READ PARISH COUNCIL

Planning Application No: **3/2013/0271**

Proposal: **Proposed erection of two detached dwellings**

Location: **Land at George Lane, Read**

Client JWPC		
Job Title Proposed development to Land at George Street Read		
Drawing Title Proposed Site Plan		
Scale 1:200@A1	Date August 2013	Drawn J Bowden

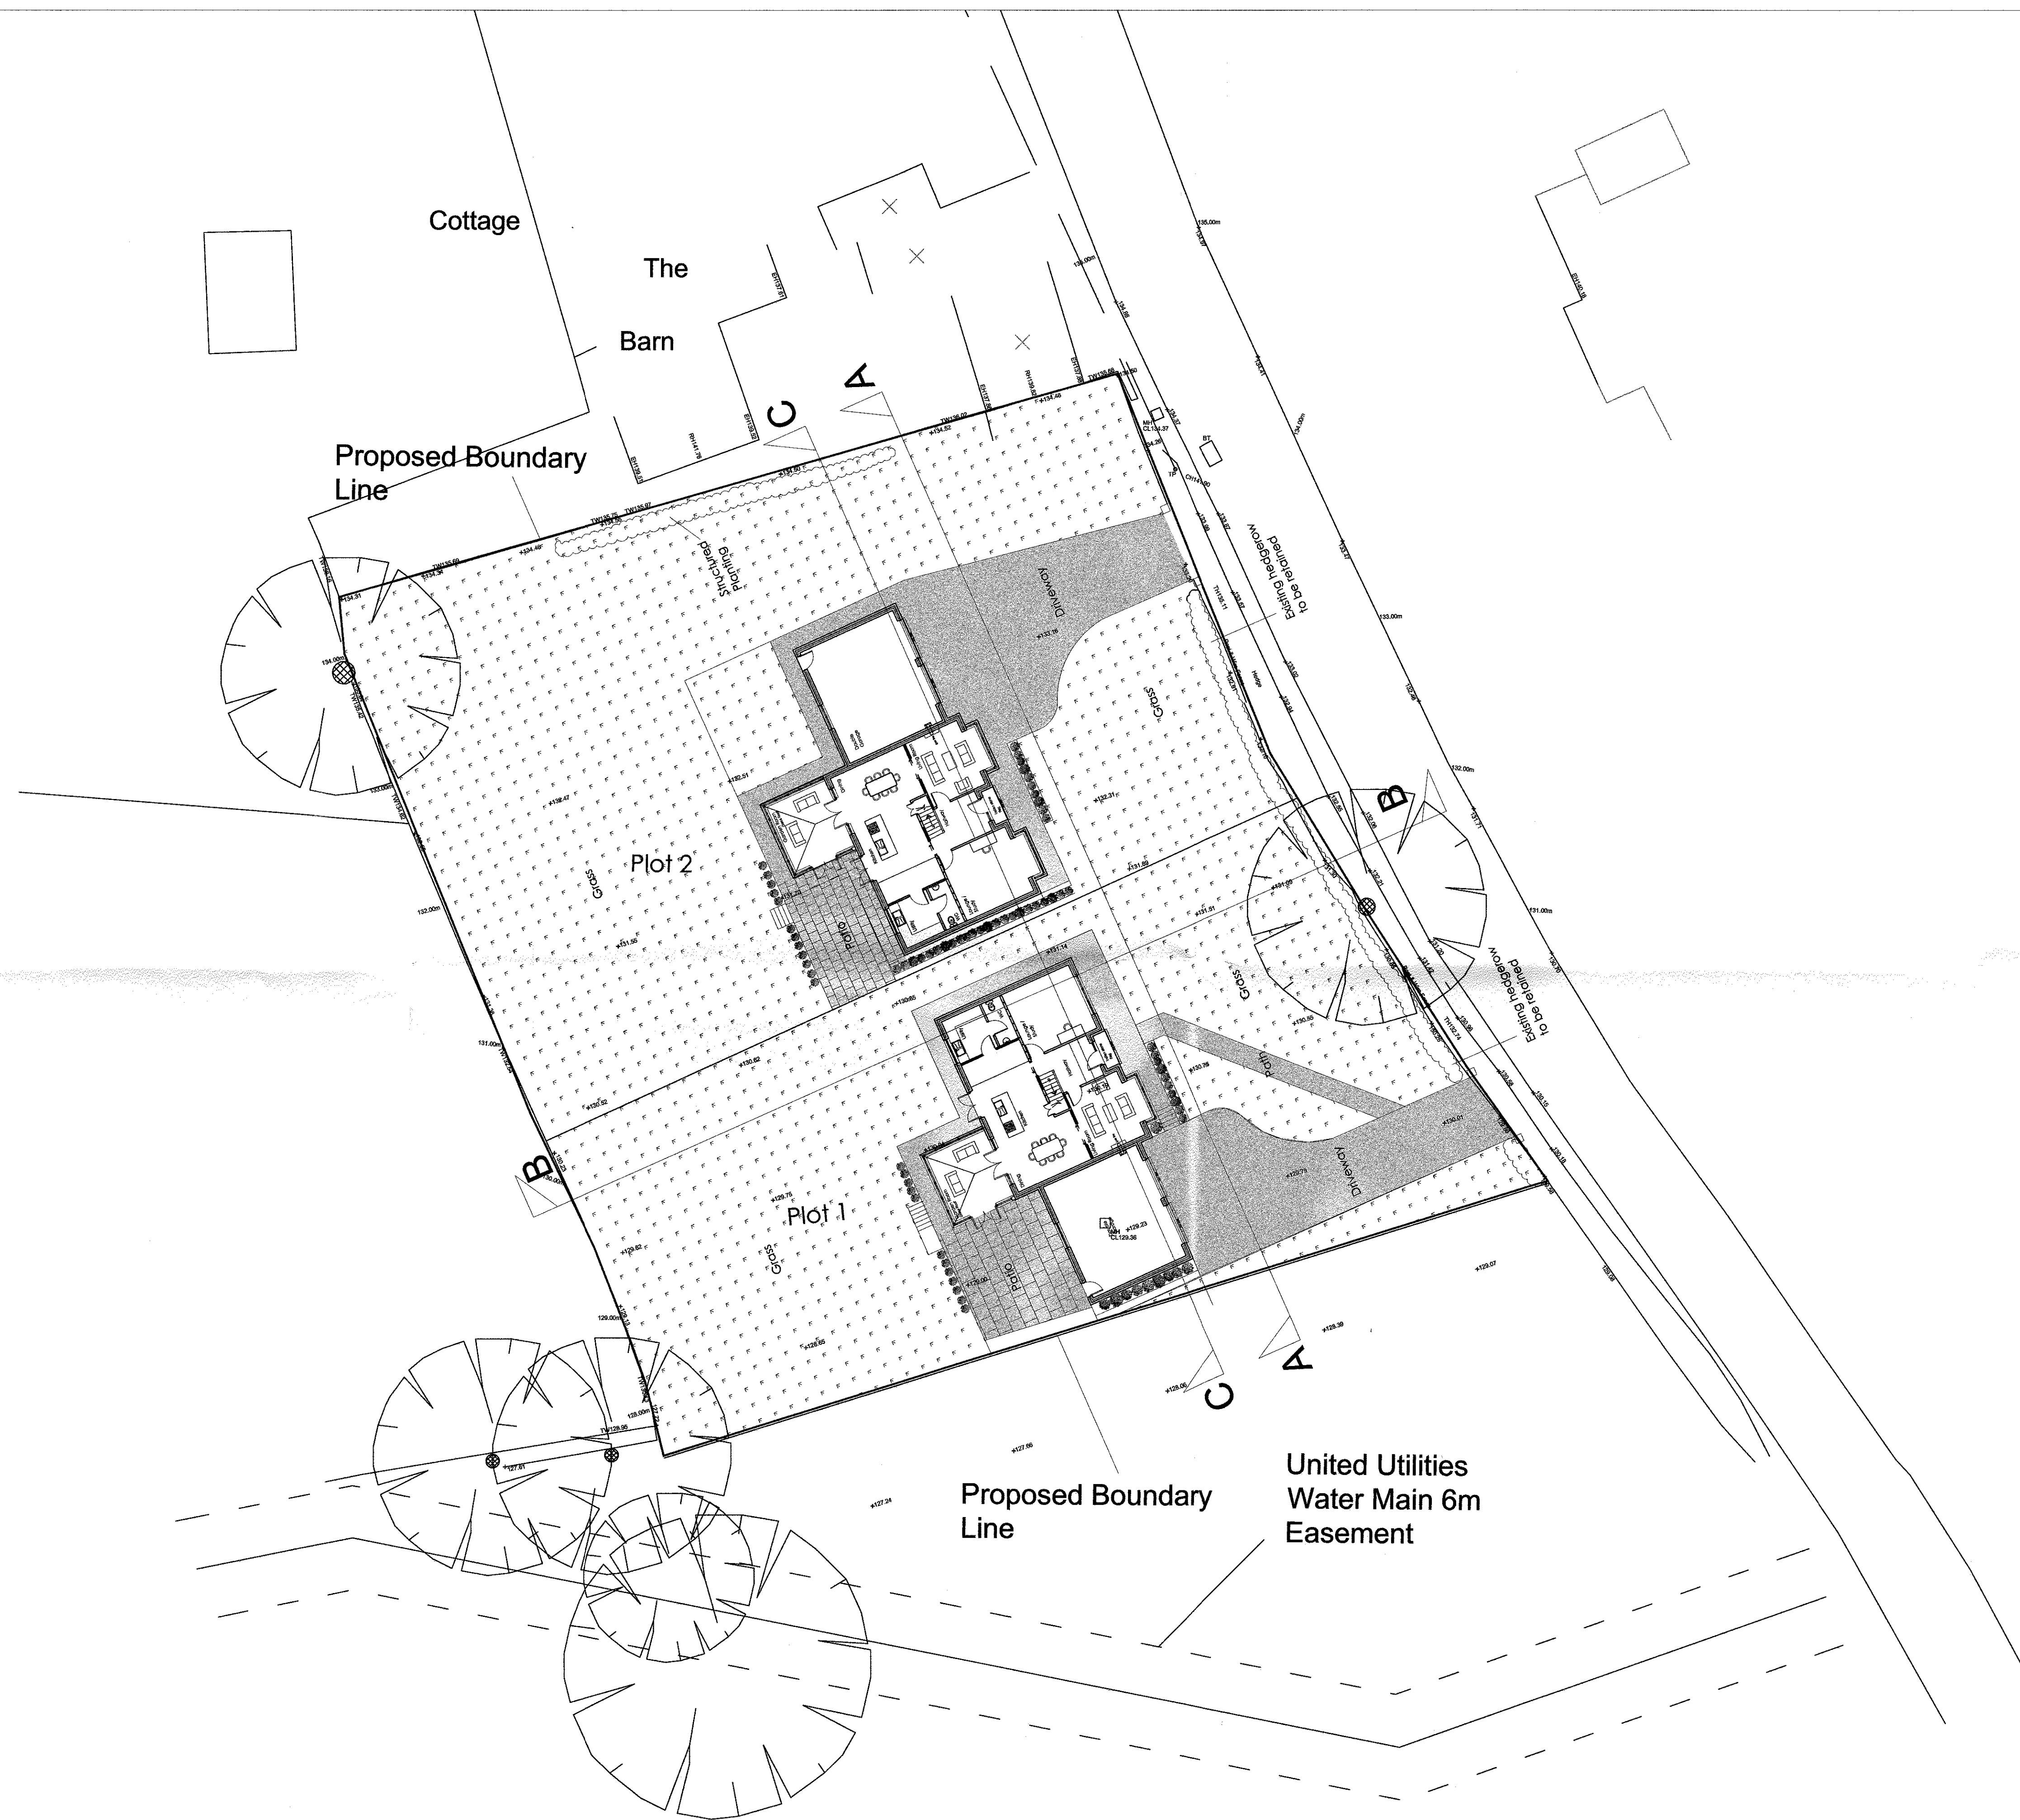
Although no strong objections to this planning proposal, the Planning Committee, Read Parish Council noted that there is no way through for the farmer to take stock to the field at the back of the site. He should not be expected to drive them on the main Whalley Road. It would be preferable if the top house had the garage on the North side as the light would be better for the Northern property. They only have small windows due to planning regulations when it was converted.
